Your ref: 06\_0139  
File no: MC-10-1603

7 March 2013

**Jacfin Ropes Creek Project Section 75W Modification of Concept and Project Approval (10\_0127 MOD 1 and 10\_0128 Mod 1)**

## Lot 121 DP 1175762, Ropes Creek Employment Precinct - Concept Plan

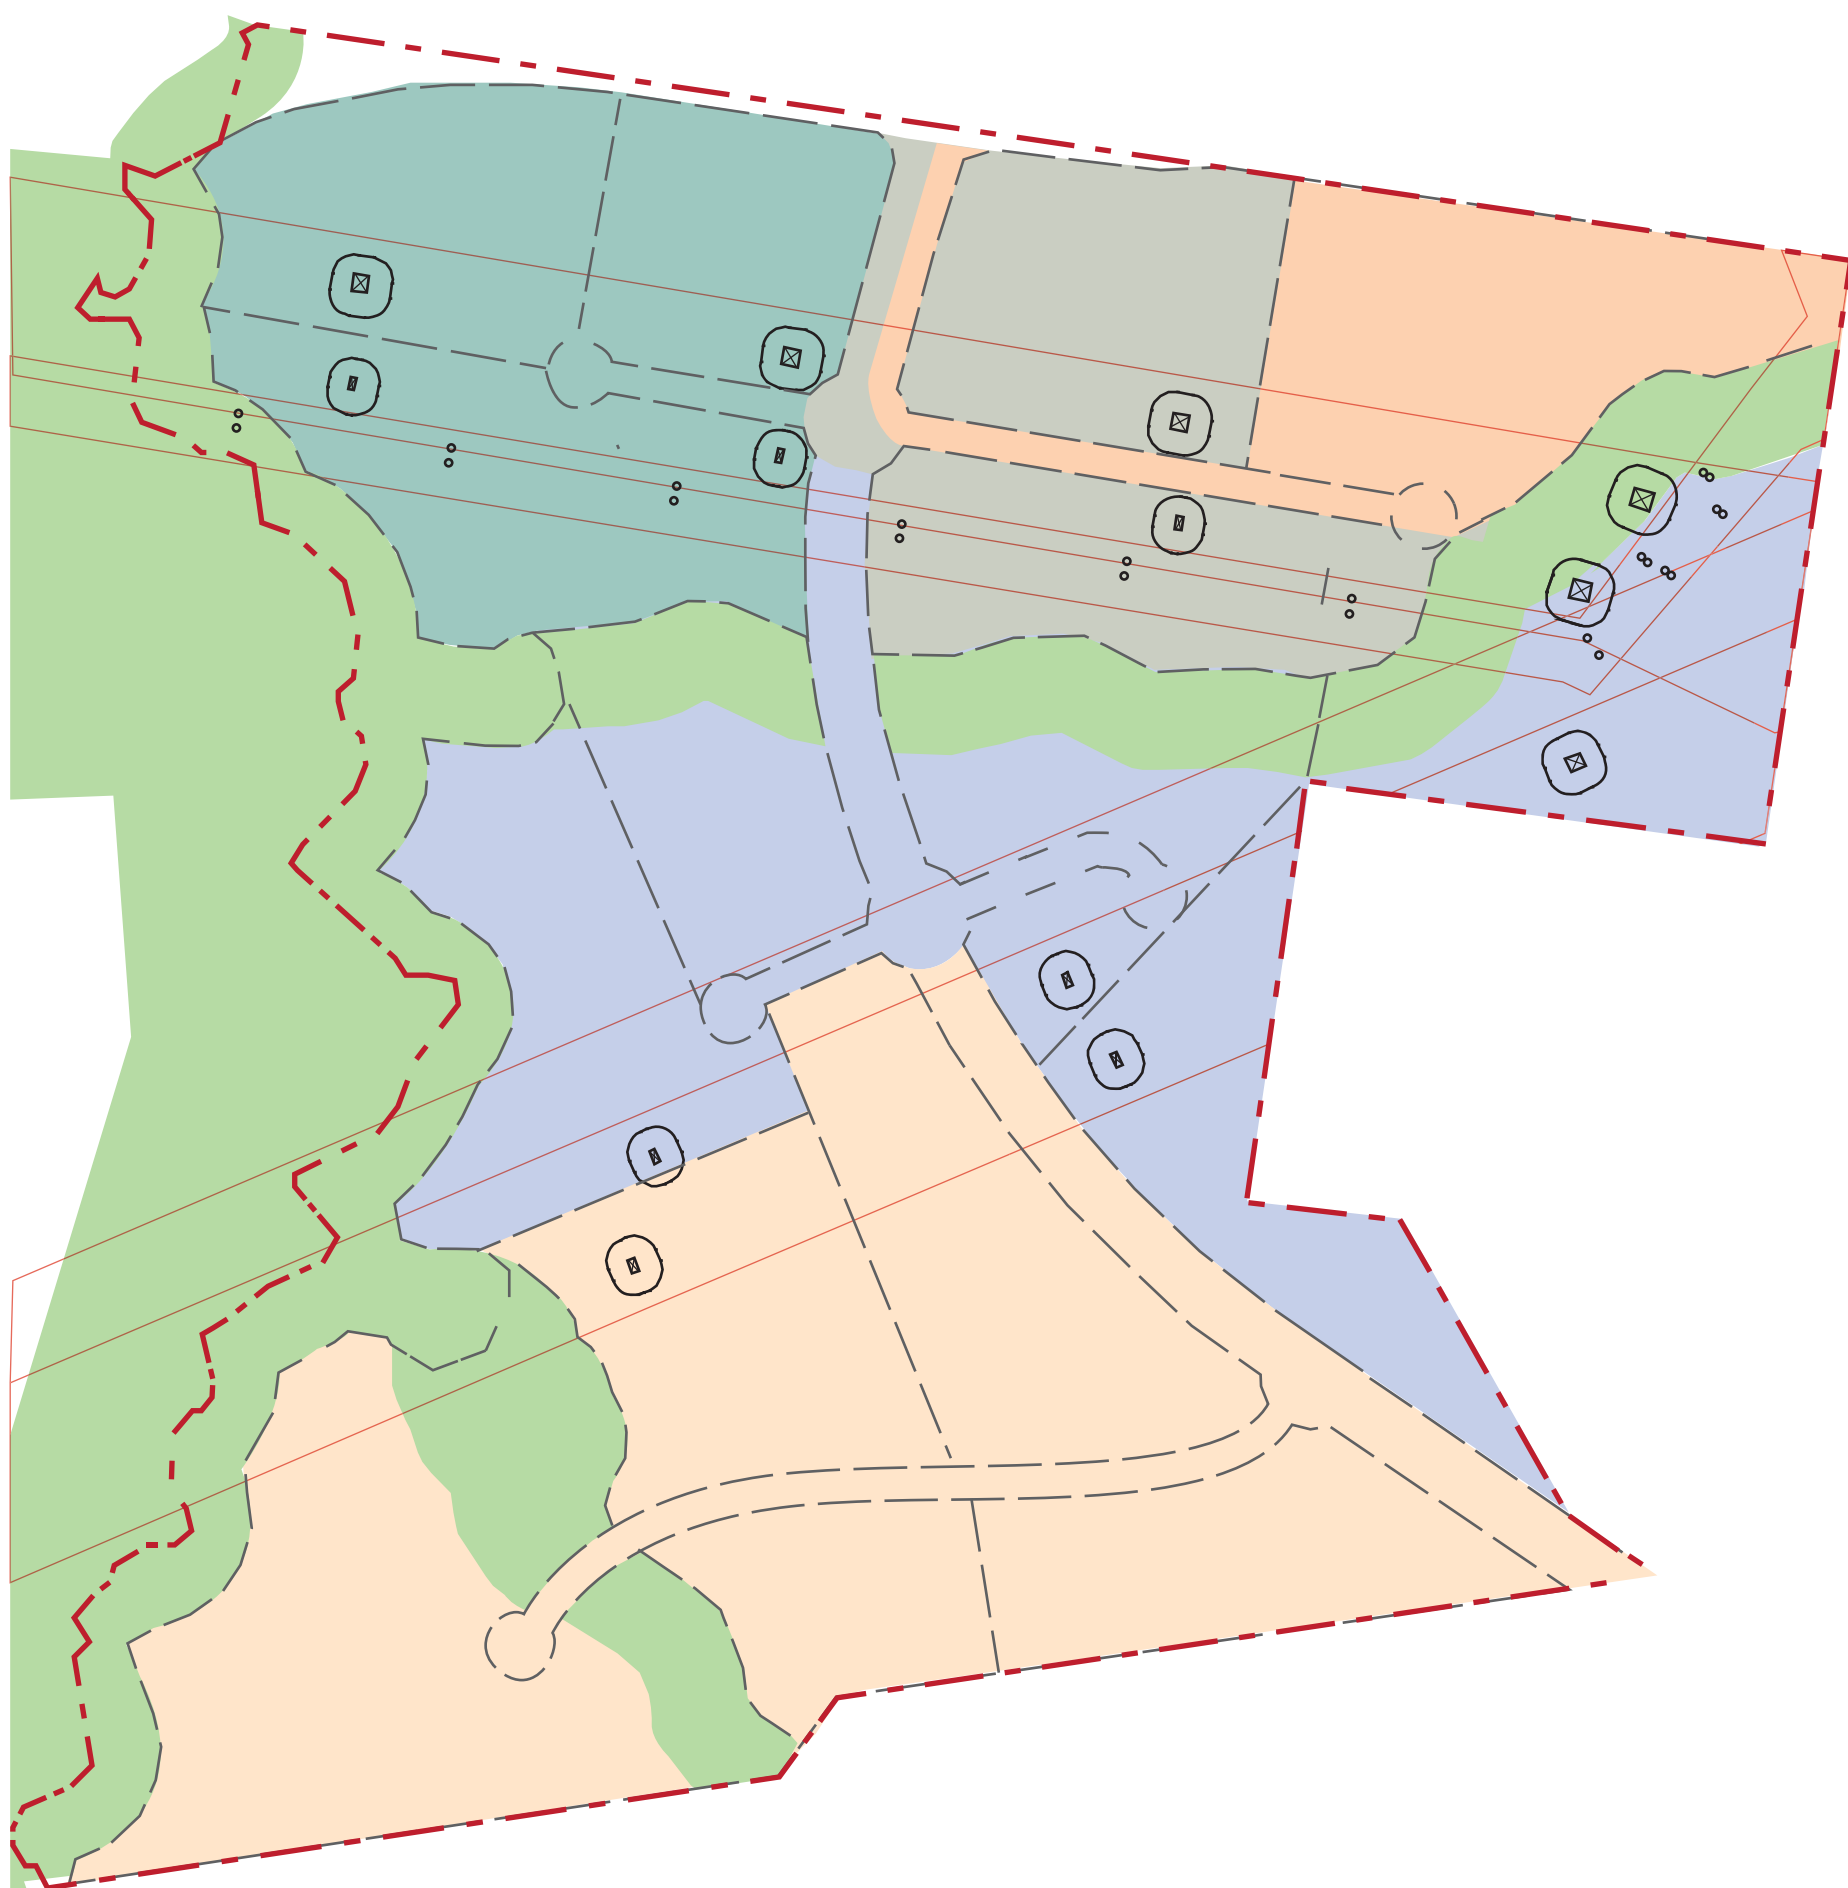
The acquisition of Lot 120 in DP 1175762 by Transgrid has isolated a triangular section of the land to the north of the lot and bounded by the E2 zone. This section of land is bounded by numerous electricity easements and cannot have a building placed on it. It could be used for the storage of materials or for parking. The best use for this land would be to link it with the Stage 1 development. It is recommended that the proposed subdivision of Lot 51 of Stage 1 include this area within the lot.

The E2 zone adjacent to the Stage 1 development is to be incorporated into the ownership of Stage 1 and proposed Lot 51 and management of the E2 zone covered by a positive covenant.

There is a catchment of approximately 60ha which flows through the Transgrid site and adjoins the northern E2 zone just upstream of the main road crossing. This catchment has been ignored in the current zoning and should be covered by an E2 zone. Consideration should also be given to a redirected flowpath contained within the electricity easement, perhaps adjacent to the Lot 120 boundary in order to maximise the use of the industrial lots (subject to levels).

The lot boundaries of the adjacent industrial development should be extended to the centre of the adjacent E2 zone. The ongoing maintenance and management of the E2 zone shall be covered by a positive covenant which ensures ongoing financial support.

Council is concerned that now, as a result of the exclusion of Lot 120 in DP 1175762 from proposed Lot 52, an irregular shaped parcel of land will be created adjacent to Local Road 2 (to its north-east) and to the south of the transmission line easement. Council is concerned that this residue lot will not be able to be developed satisfactorily in accordance with any DCP controls (having regard to setbacks, access, easements and provision of parking).

Further, any building footprint for this site may be misleading and pre-emptive of significant variations that will need to be given by any approval authority to fit any sort of acceptable built form. The applicant has not satisfactorily demonstrated how this can work in reality. As such, indicative building footprint on this residue parcel should be deleted from the concept plan and this residue used in conjunction with the land opposite.
